A47 Blofield to North Burlingham Dualling

Scheme Number: TR010040

9.24 Request for a Non-Material Change to the Application

REQUEST FOR A NON-MATERIAL CHANGE TO THE APPLICATION

HE551492-
GTU-LLO-000-DR-BL-00011

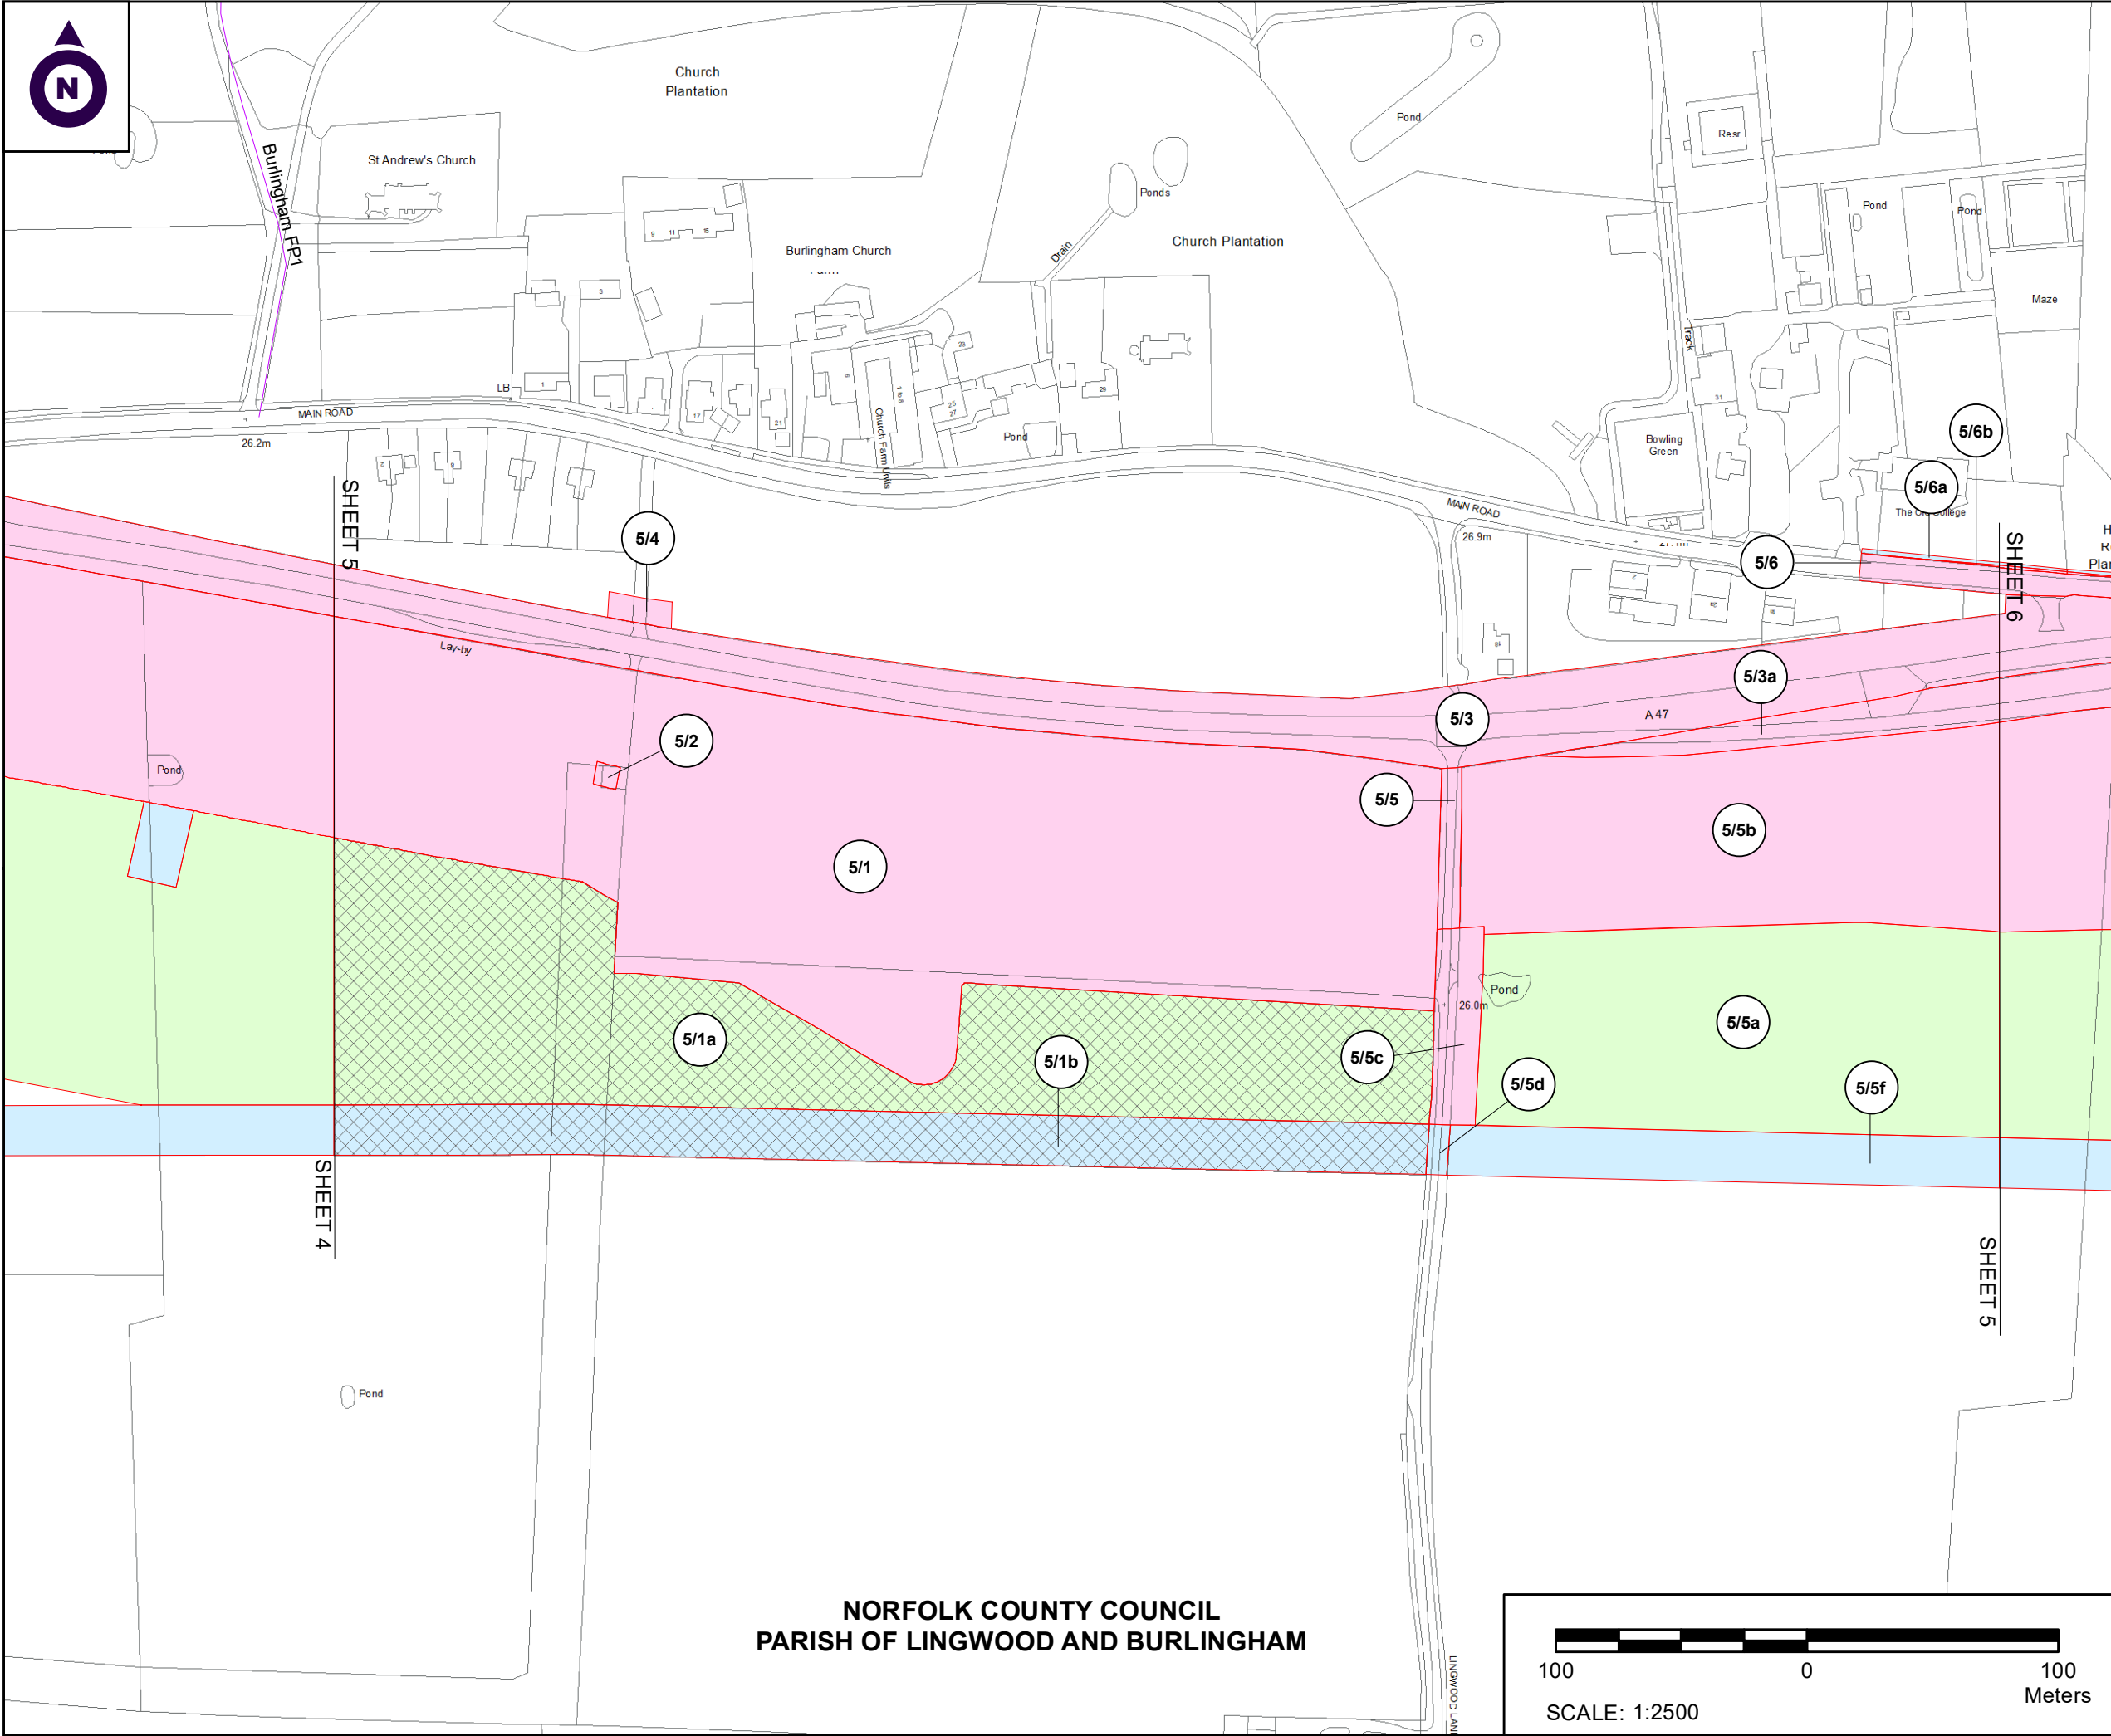
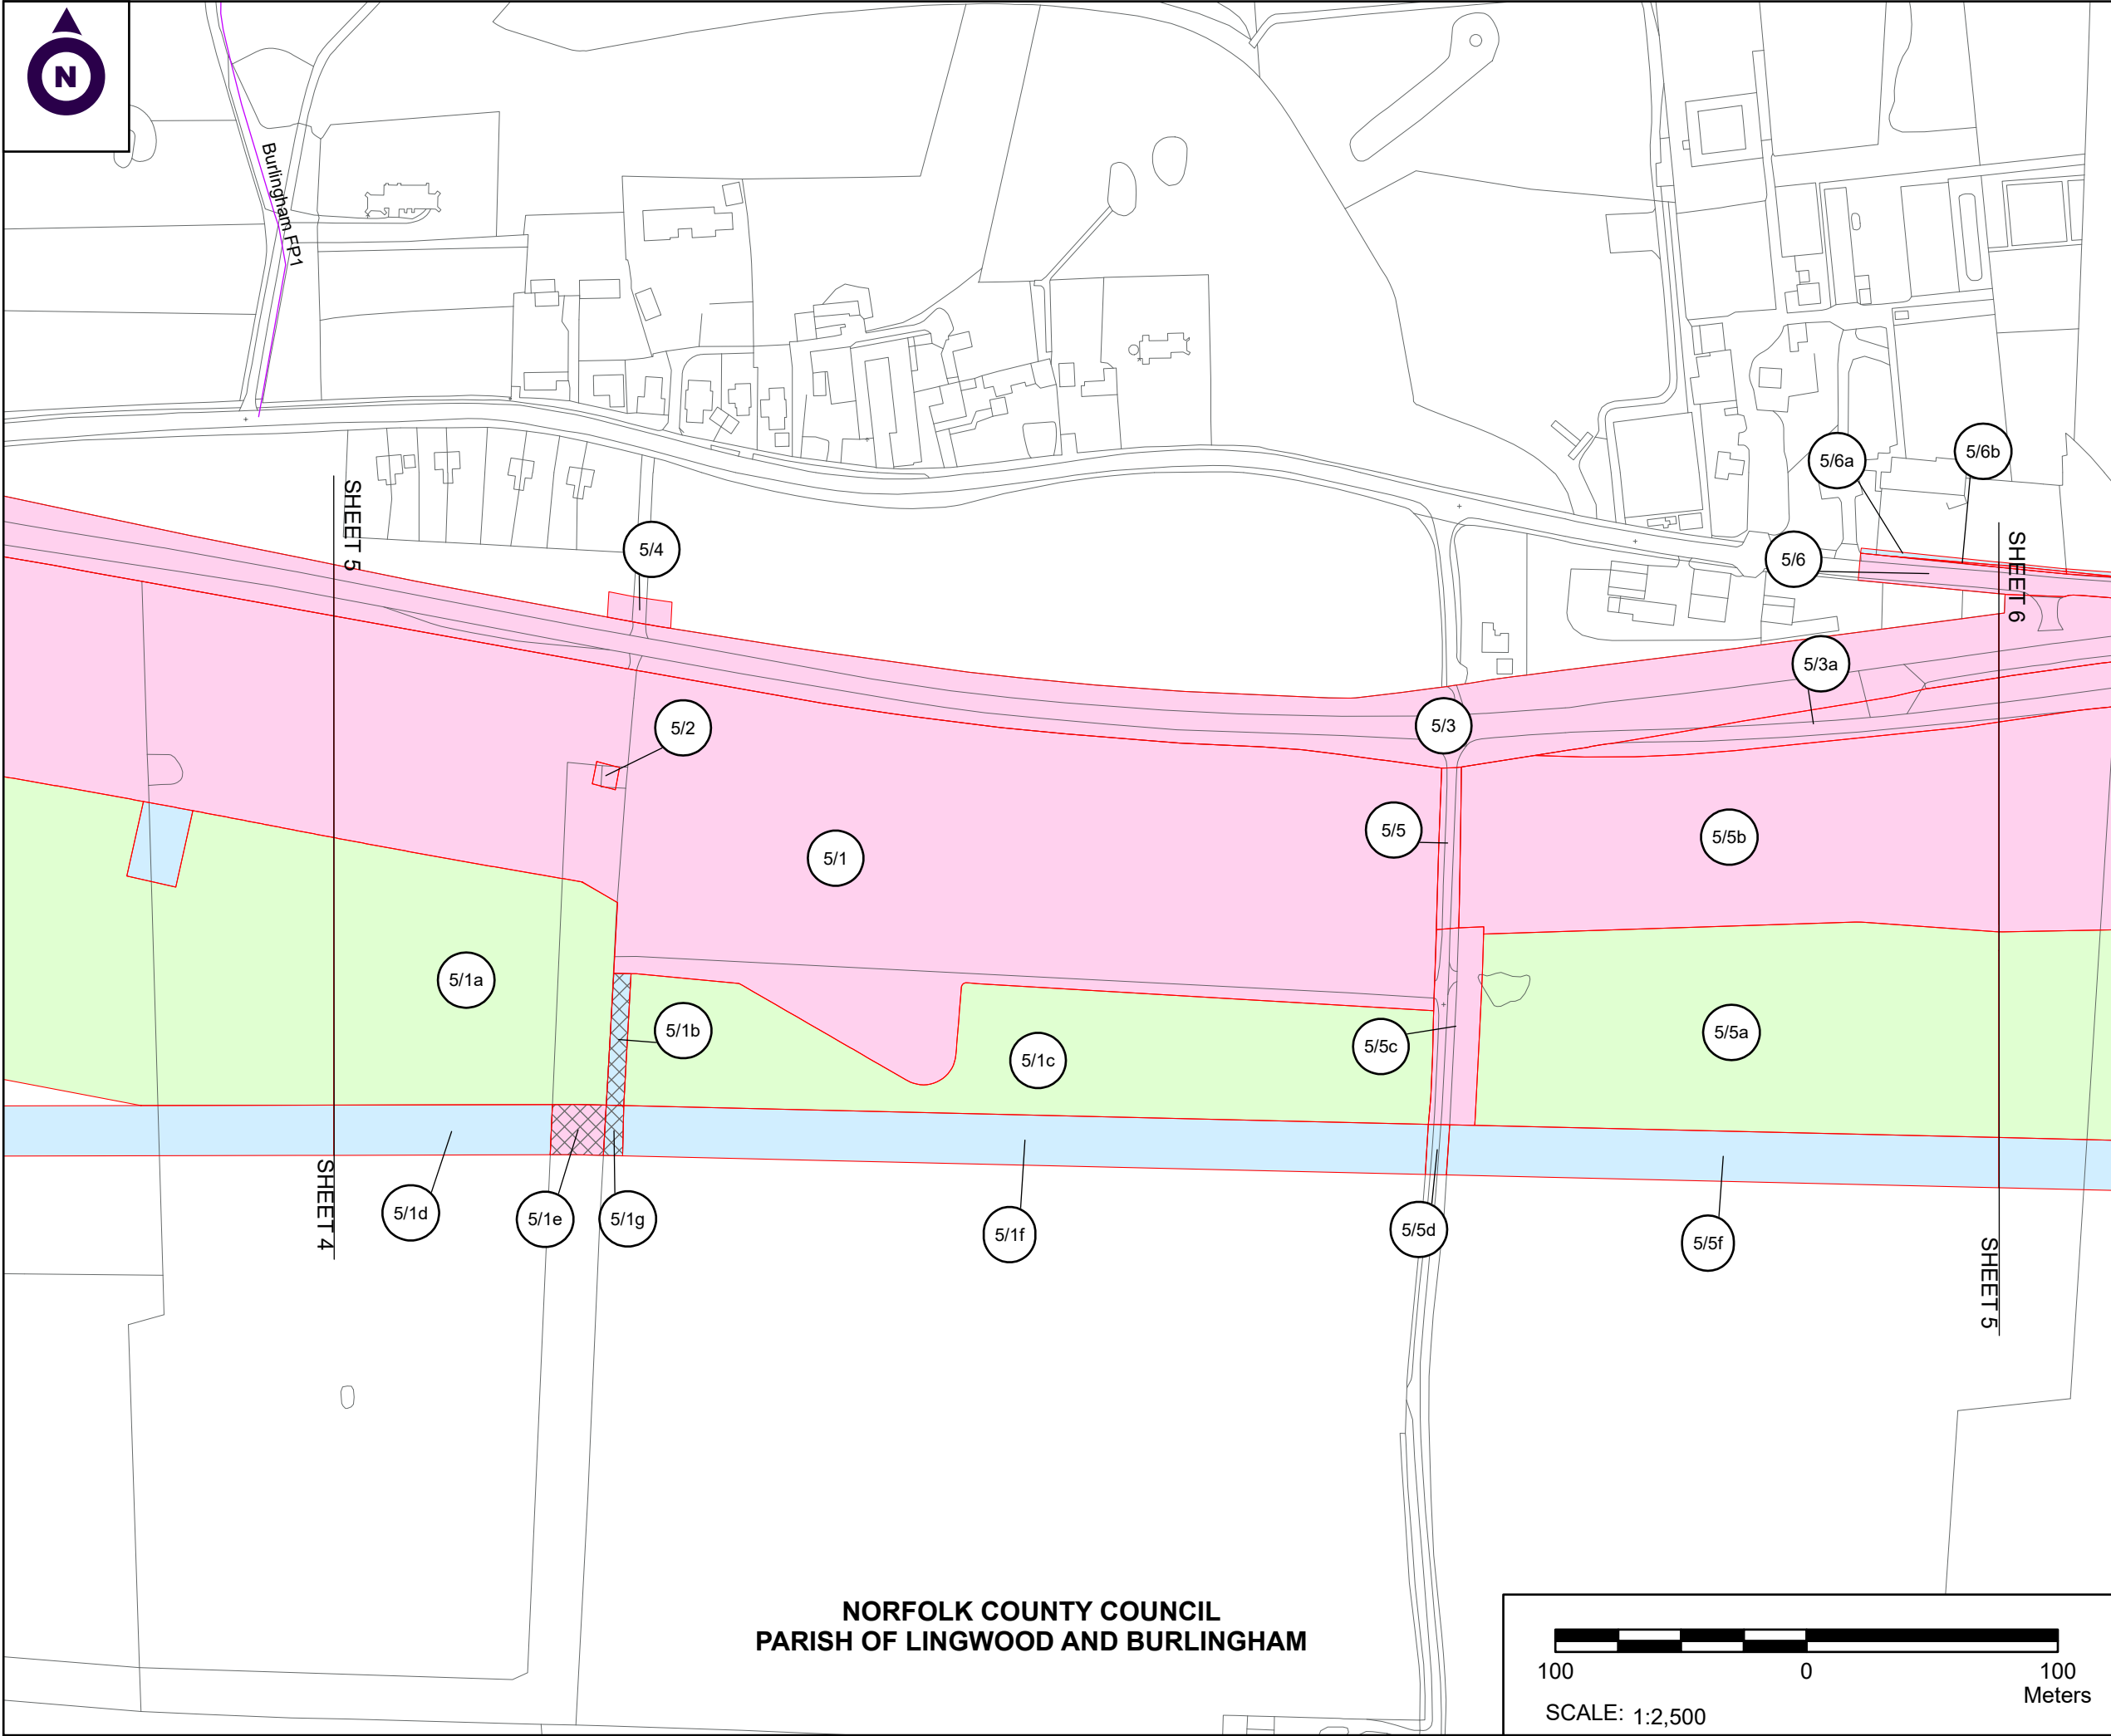
- 2.1.4 The Existing Block Valve Site is shown on sheet 5 of the Land Plans as plot 5/2 (**REP4-002**).
- 2.1.5 The Existing Block Valve Site comprises a block valve site, which is a fenced-off, above-ground facility situated where an existing gas main on a north-south alignment (the North-South Gas Main) crosses a second existing gas main on an east-west alignment (the Existing East-West Gas Main) which is to be diverted to a new route (the Diverted Gas Main) (see Work No.5, Schedule 1 to the dDCO (**TR010040/APP/3.1 Rev 5**) (submitted at Deadline 7)).

- 2.1.7 To allow the provision of the New Block Valve Site, a new permanent acquisition plot (plot 5/1e) has been added to the Land Plans (**REP4-002**) and the Book of Reference (**REP6-002**) on land for which temporary possession was previously sought. It is anticipated that this land would be vested in Cadent after completion of works. The extent of this plot reflects the limits of deviation for Work No.5, and a degree of uncertainty as to the precise location of the North-South Gas Main (historical records as to the location of the apparatus of statutory undertakers is generally imprecise).
